Arun District Council
Arun Civic Centre
Maltravers Road
Littlehampton
West Sussex BN17 5LF
Planning & Building Control General Enquiries
Tel: (01903) 737756 Fax: (01903) 730442
Dx: 57406 Littlehampton
Minicom: 01903 732765
e-mail: planning@arun.gov.uk
website: www.arun.gov.uk/planning

Application No: BR/94/22/HH
Site Address: 38 Bassett Road Bognor Regis PO21 2JH
Description of works: Roof extension to create 2 additional annex including the installation of 4 x dormers and balcony and alterations to fenestration/openings.

Thank you for your internet representation made on 30th May 2022 which has been recorded as an objection with the comments as follows:

Proposed West Elevation

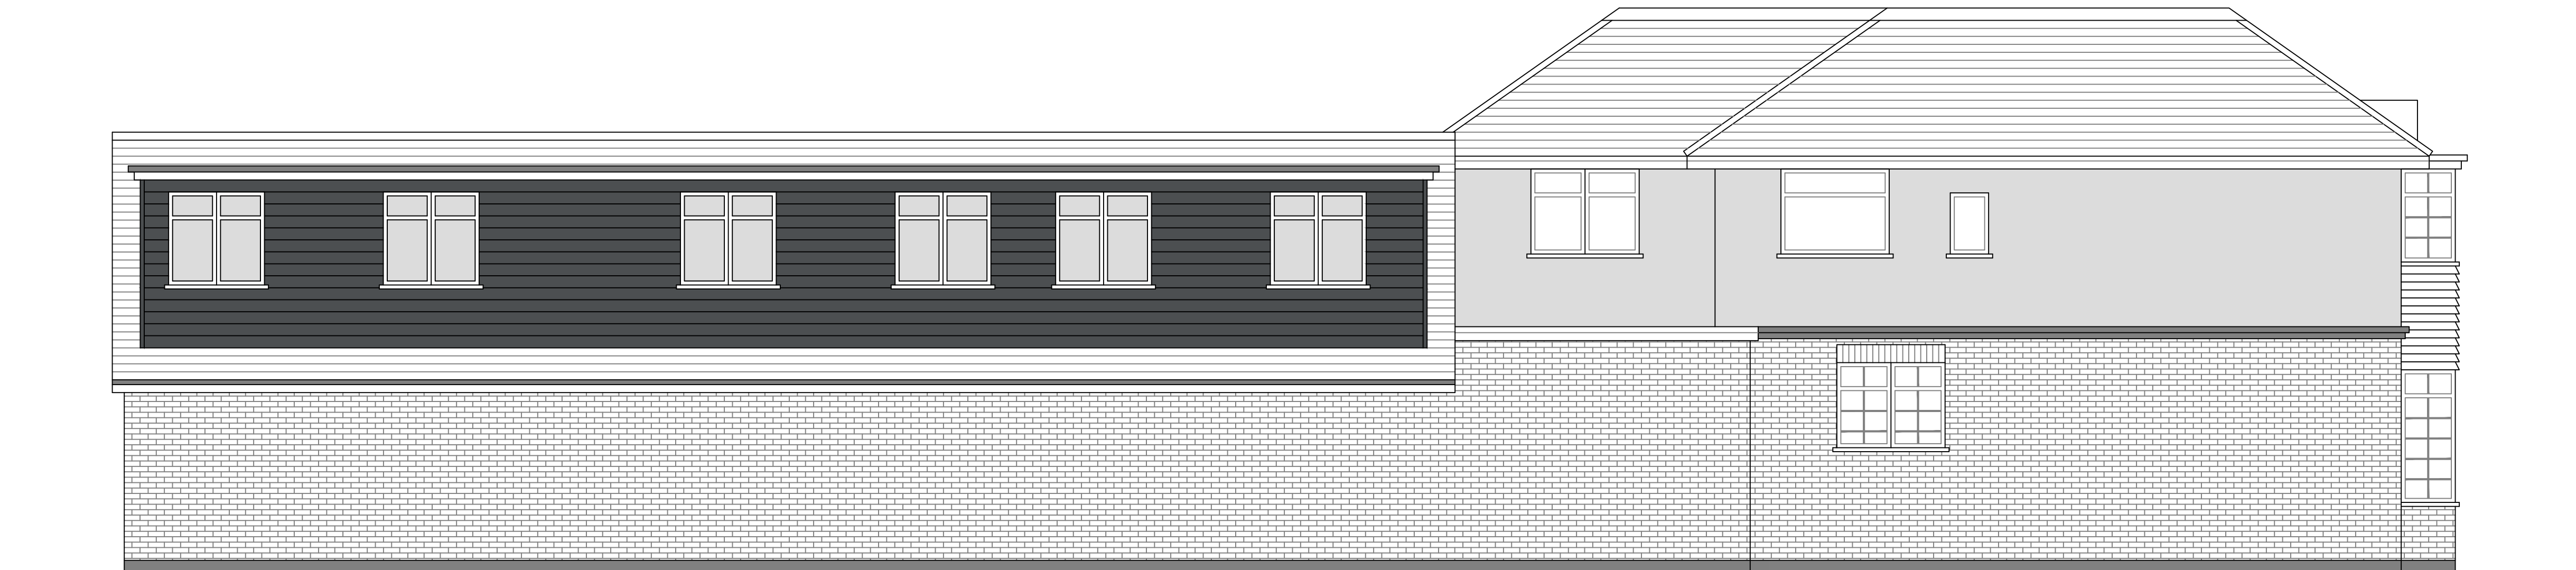
The proposed balcony will impose directly onto my property to the west and also to the properties to the south
